City of Albuquerque

December 1, 1988

RE: DRAINAGE PLAN FOR AN ADDITION TO STATKUS ENGINES (J-14/D81)
RECEIVED 11/14/88 ENGINEER'S STAMP DATED 11/14/88

W. Reed Edge1, W.S., P.E. CONSULTING ENGINEER 601 VASSAR DR NE ALBUQUERQUE, NM 87104 15051 252 2875	
STORAGE BUILDING STATKUS ENGINEERS	11/3/88
JOB # 88019 LEASE-A PORT/JONES STATUS	
1/16" = 1' 0" SIZE C	SH 1 OF 2

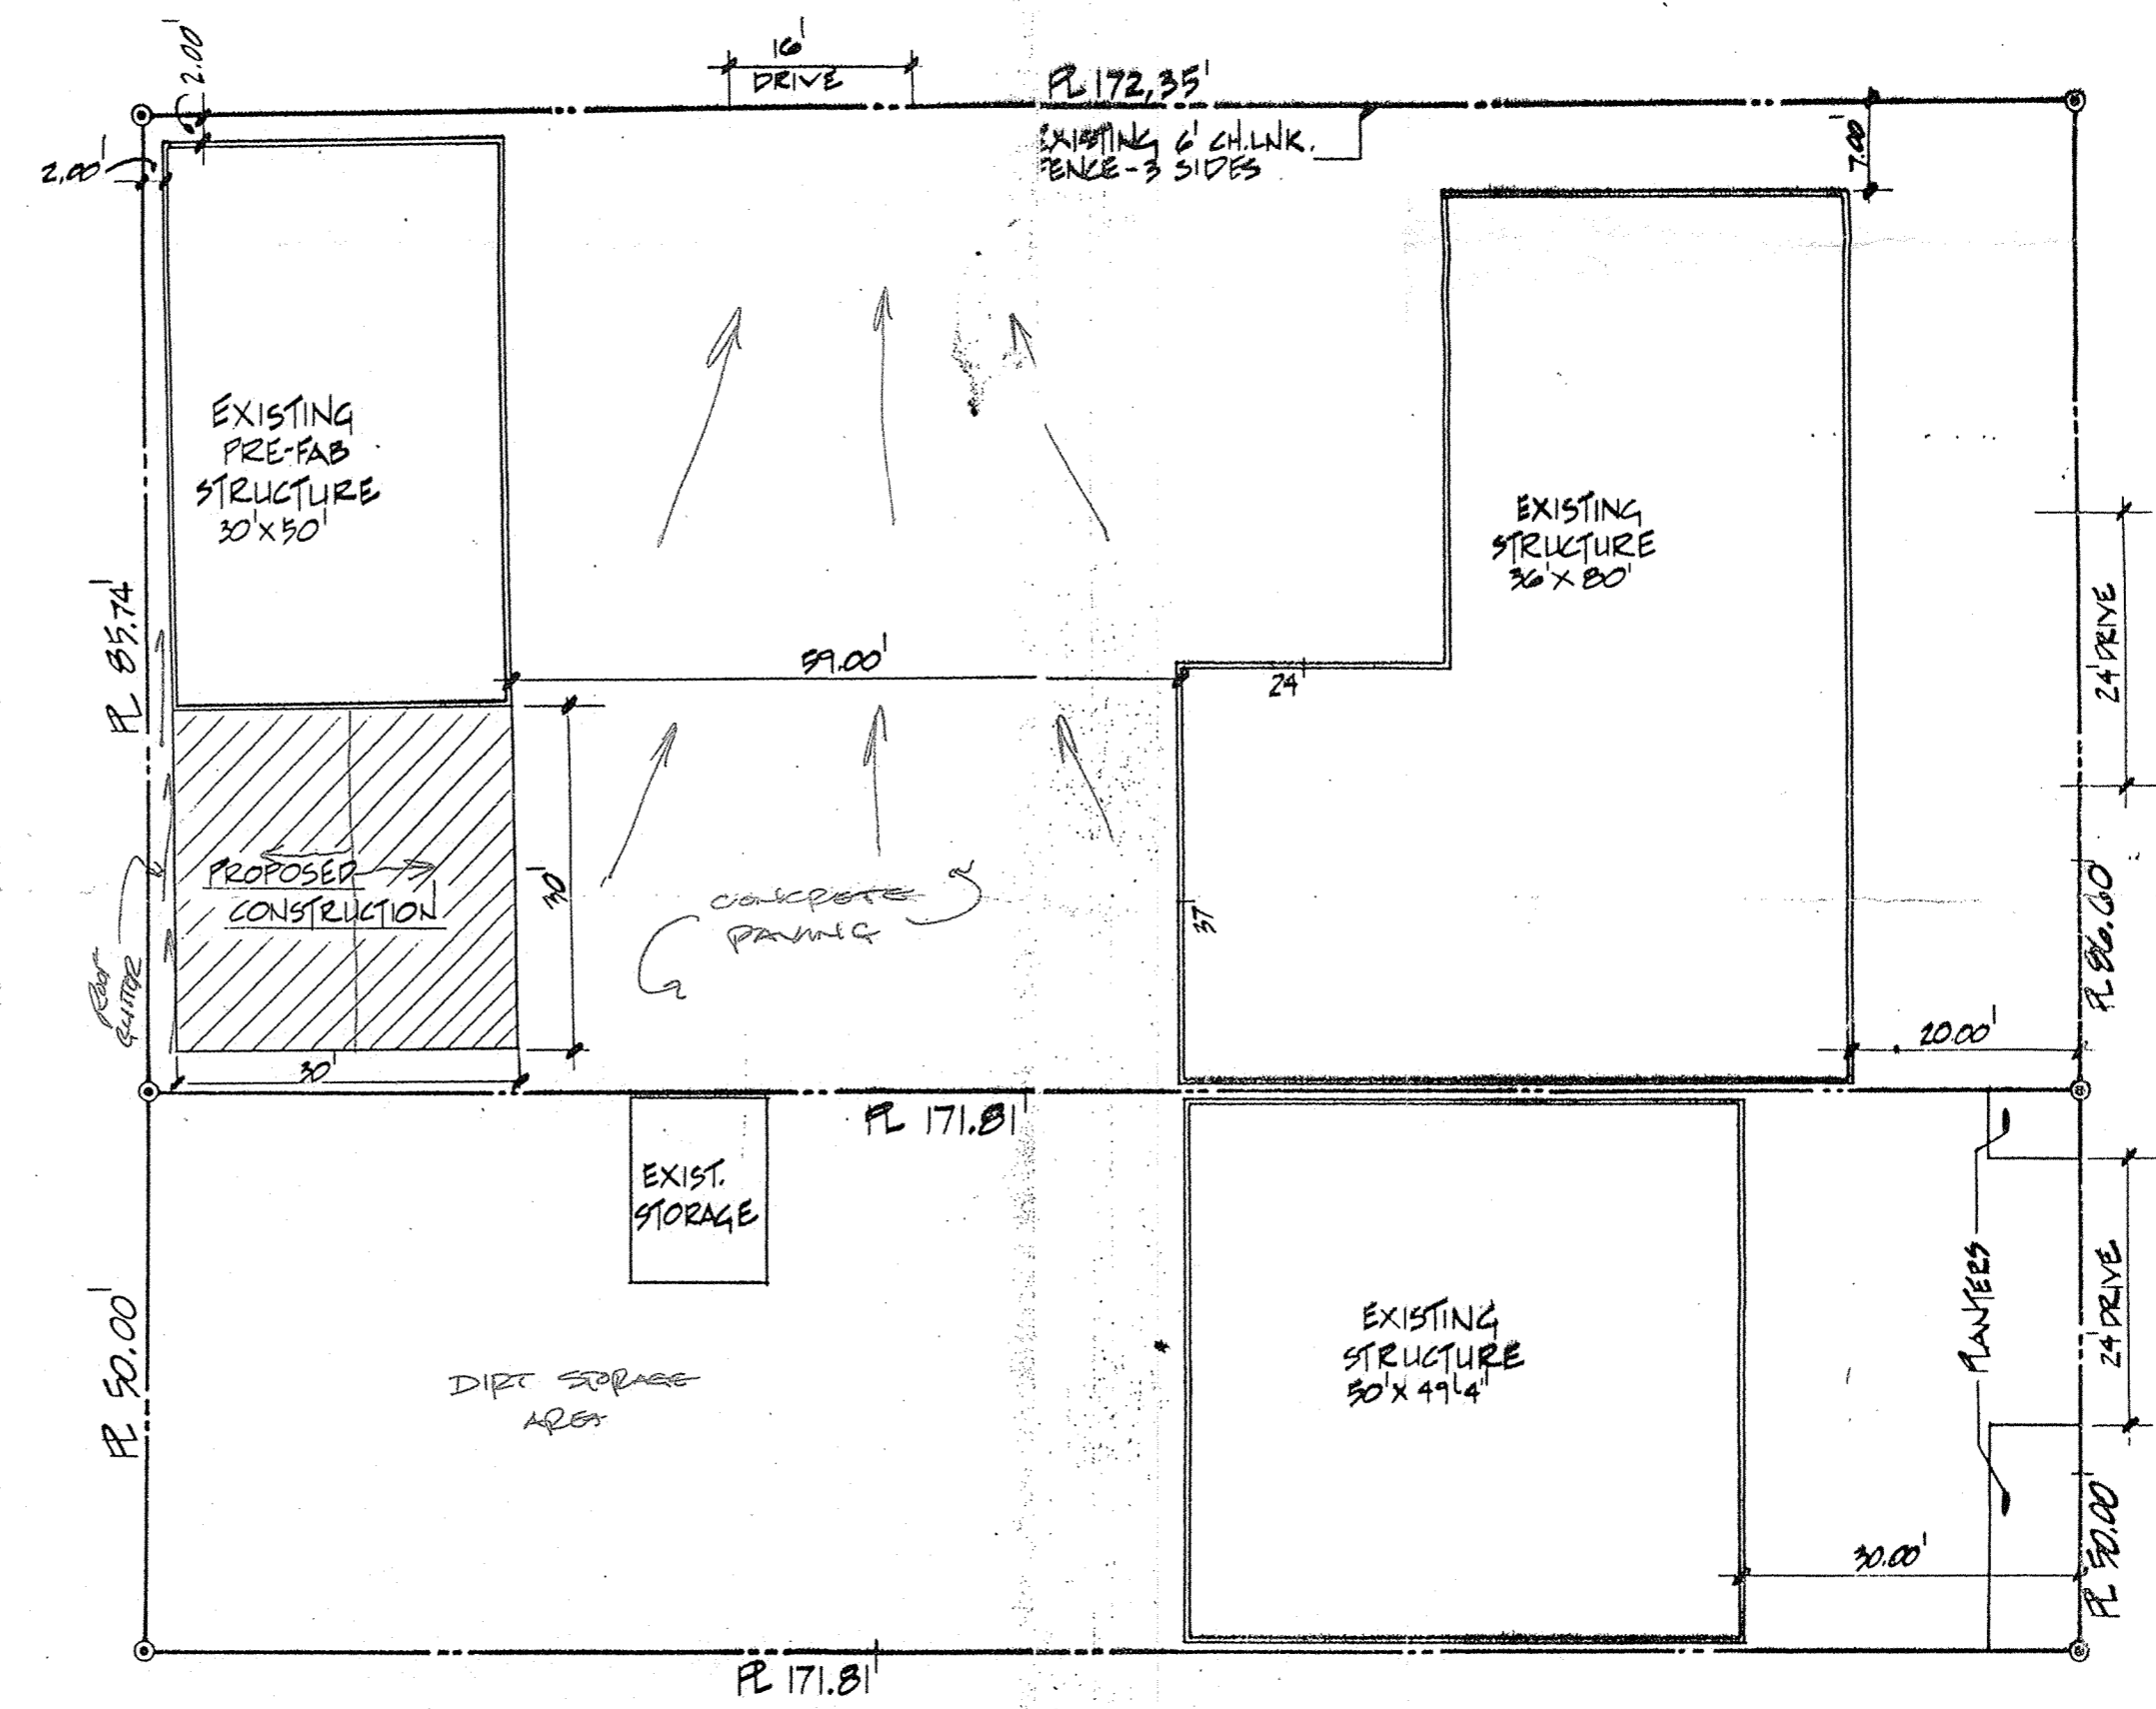
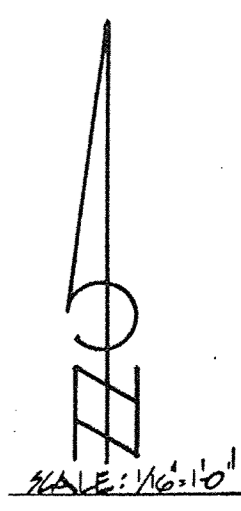
1. Finish floor elevation to full mean sea level designation of proposed building and existing.
2. Location, description and elevation of:
 - a. ASC bench mark used;
 - b. T.B.M. located on site.
3. Roof drainage of proposed building must be routed towards the concrete paved area.
4. Few spot elevations to demonstrate how the runoff will be routed towards Aspen Street.
